Health Central Coast Local Health District

I write in response to your email of 20 December 2019, regarding the State Significant Development Application 10414, mixed use development at 8-16 Watt Street, Gosford (Gateway site).

Thank you for the opportunity to review the Secretary's Environmental Assessment Requirements (SEARS) and Concept Application for the Gateway site project. The Central Coast Local Health District's (the District) Health Planning, Health Promotion, Public Health Services and Clinical Services have collaborated to prepare this response.

1 TYPICAL BASEMENT PLAN (LEVELS B2-B5)
DA534 1 : 500

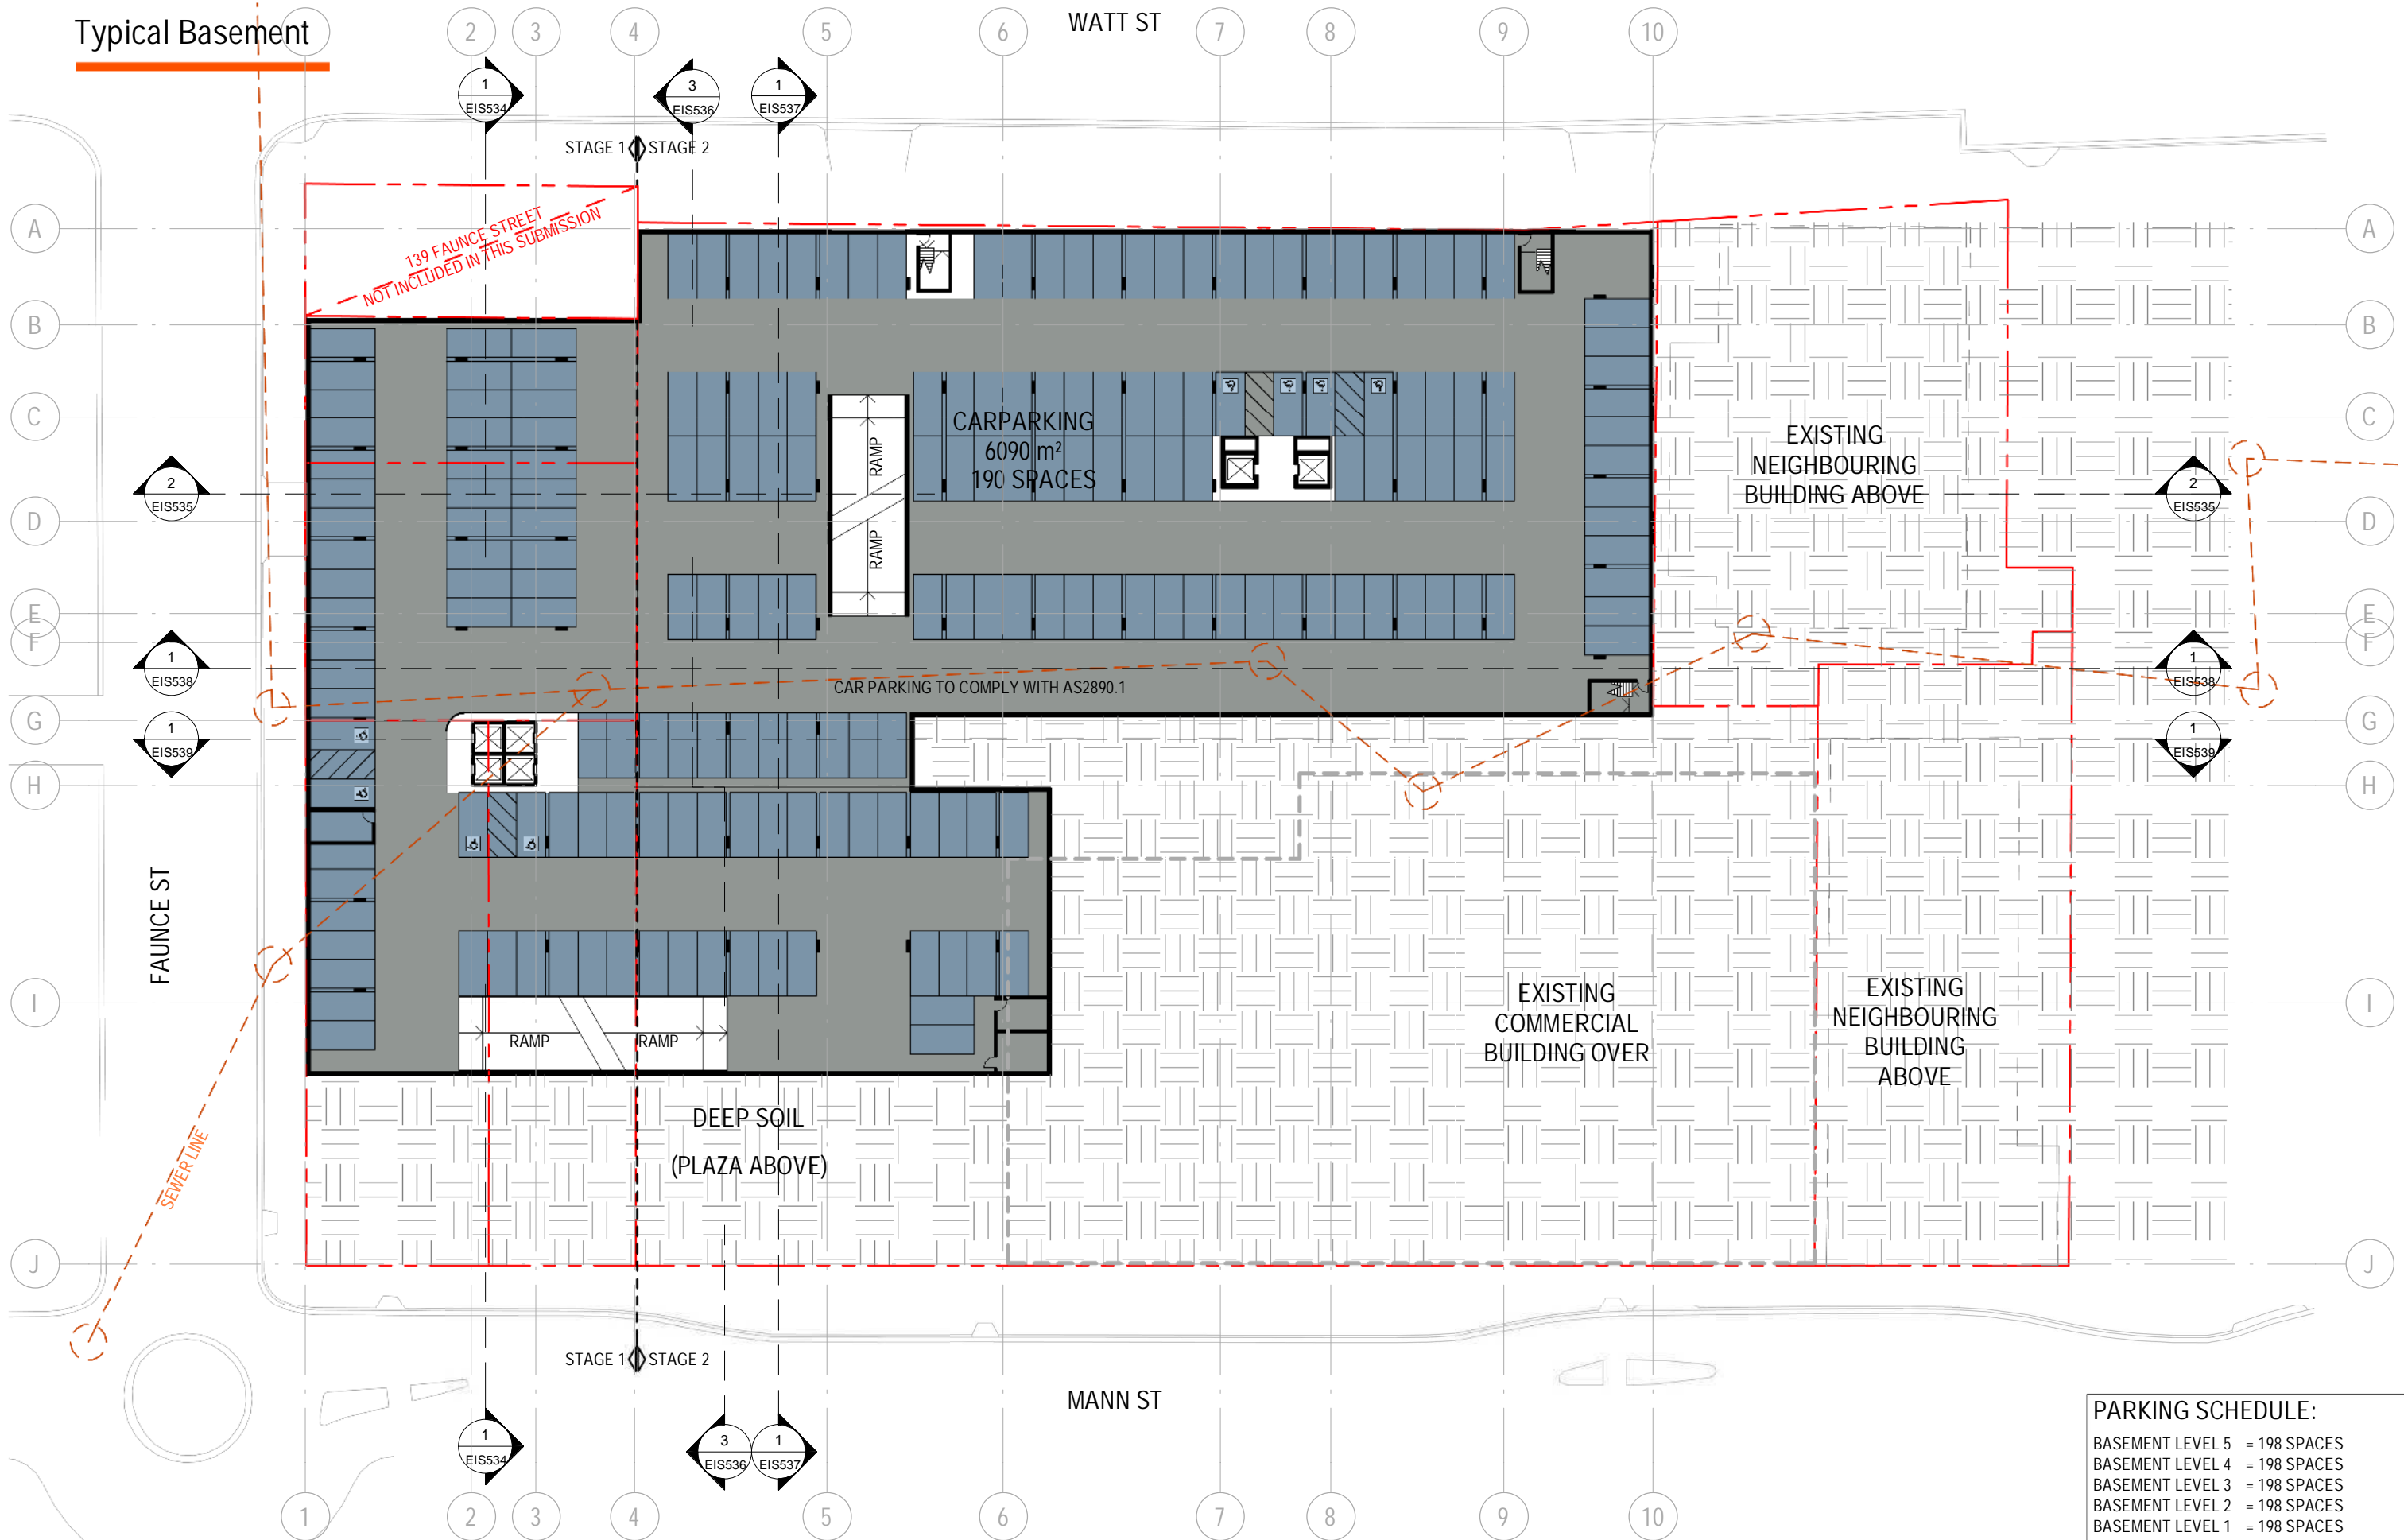
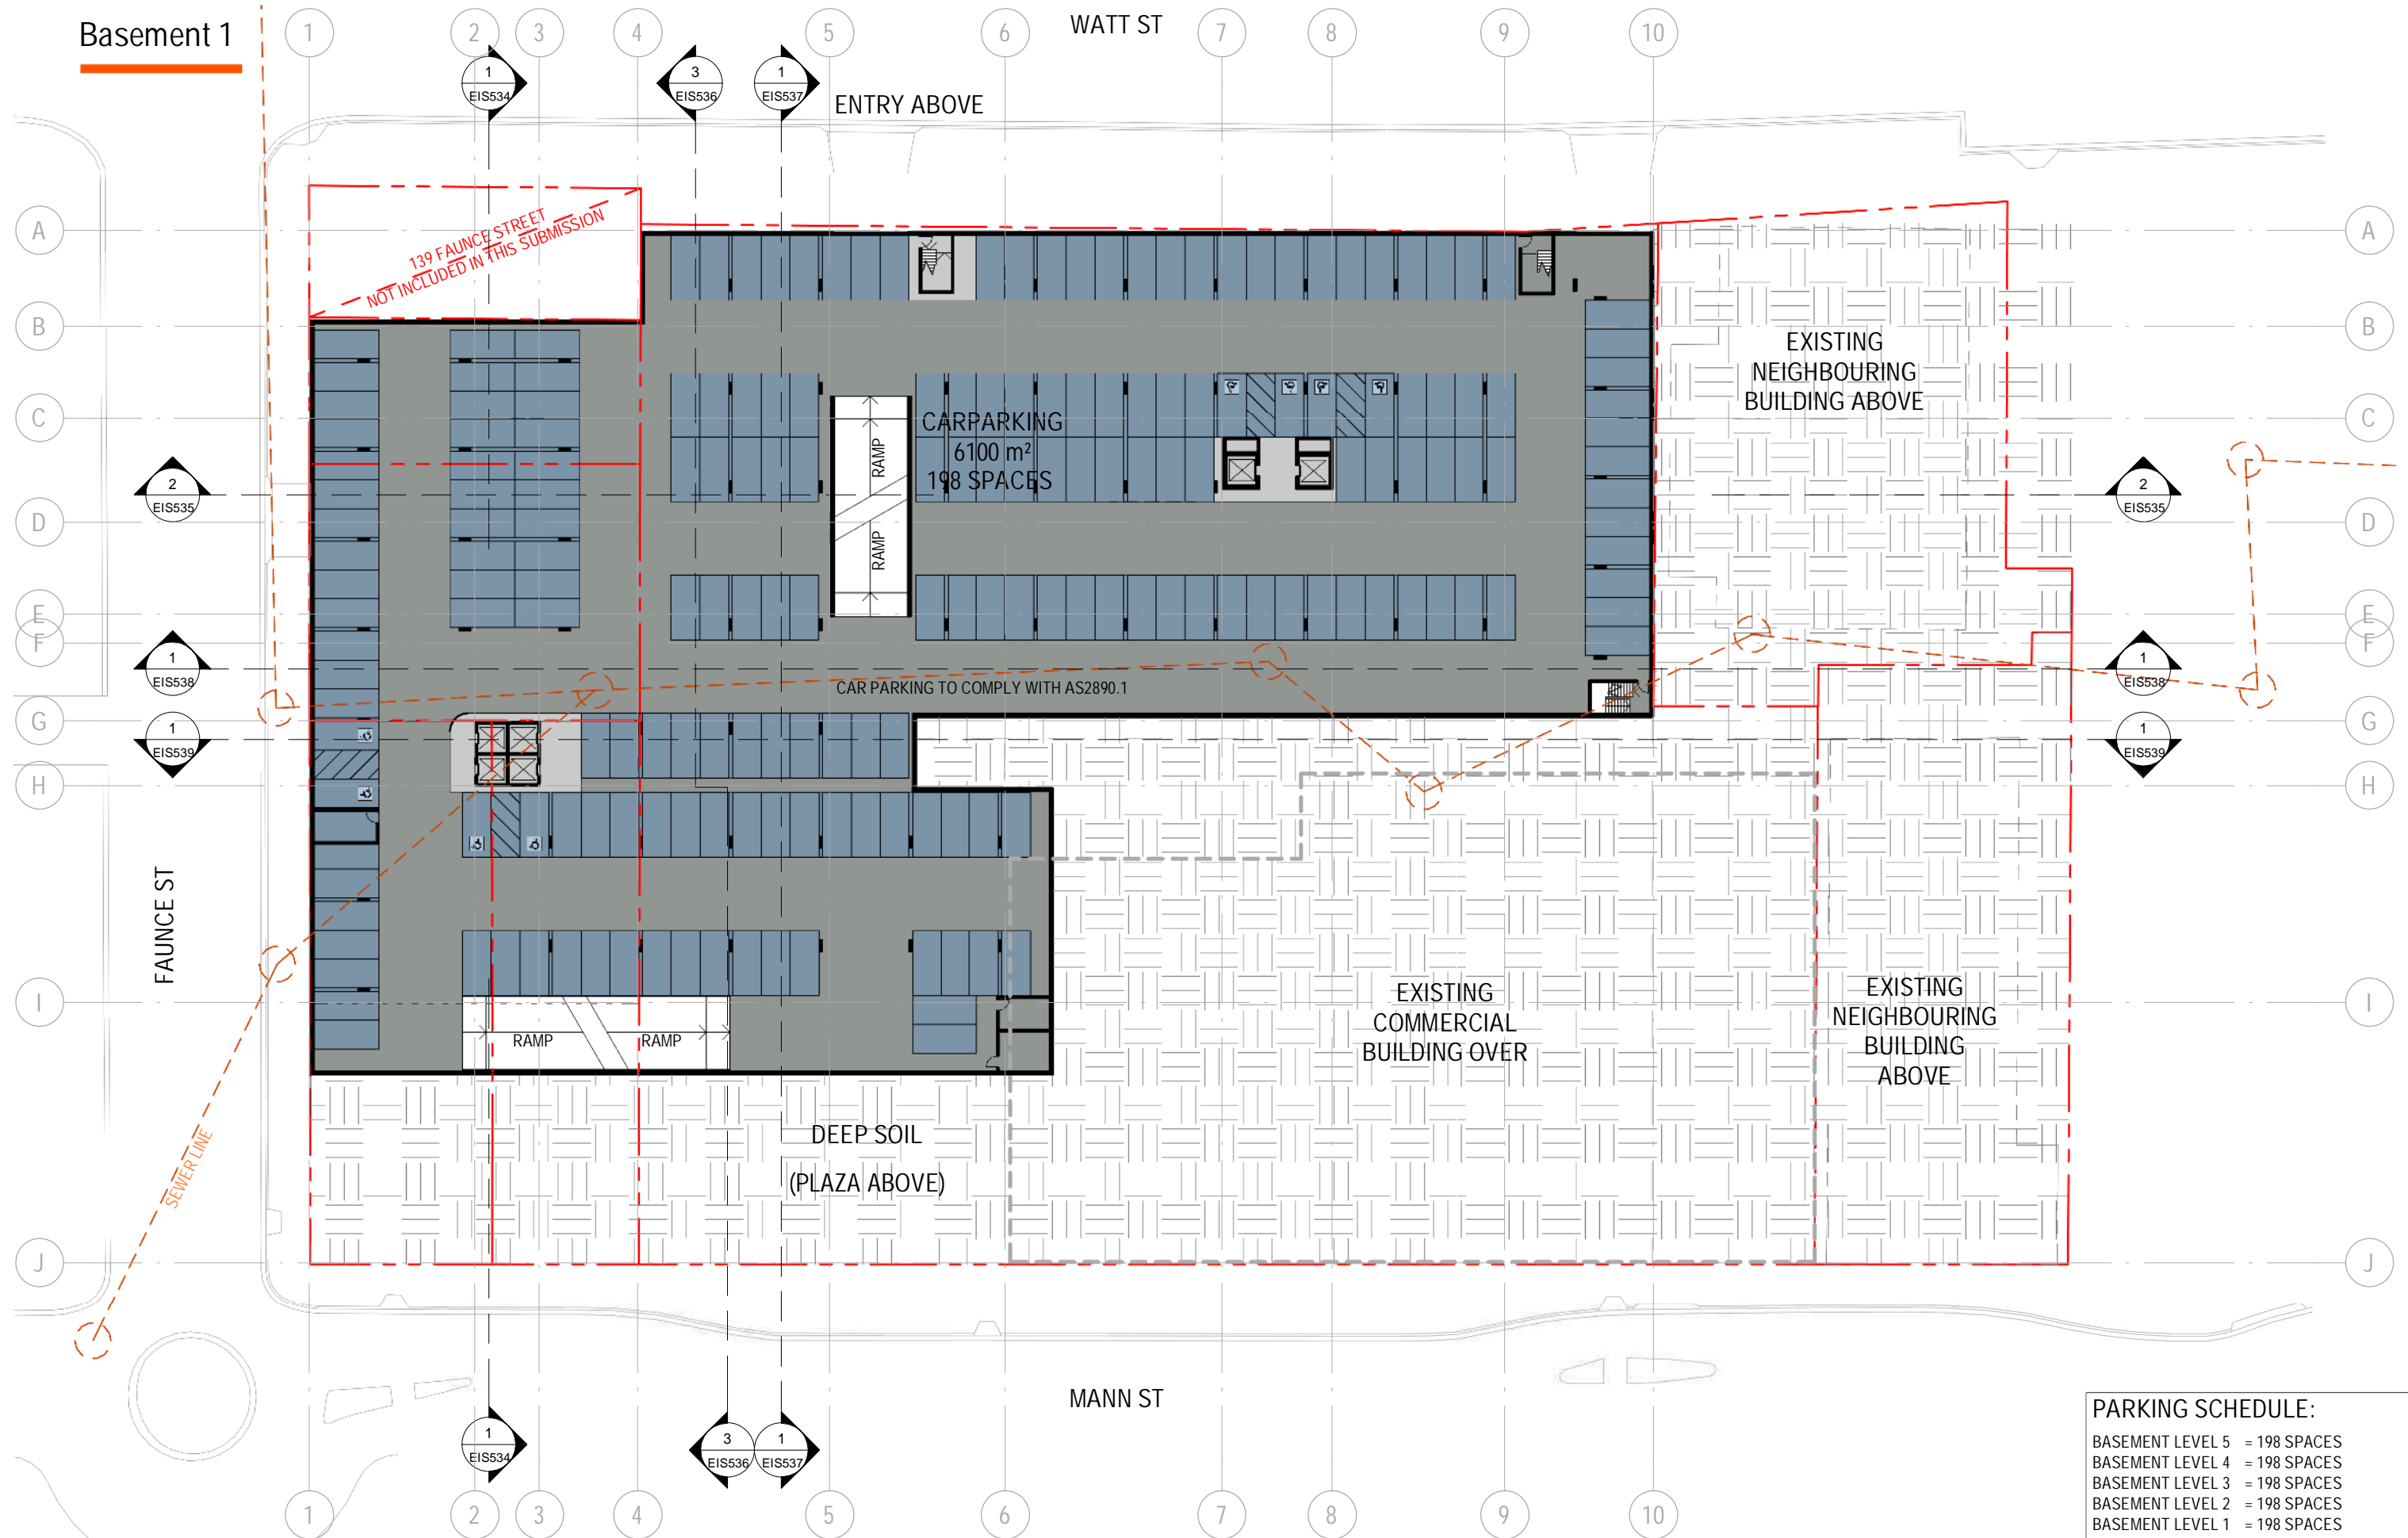
- for car parking, the anticipated number of car parking spaces to be made available and how these numbers will be distributed between the proposed residential and commercial/retail areas
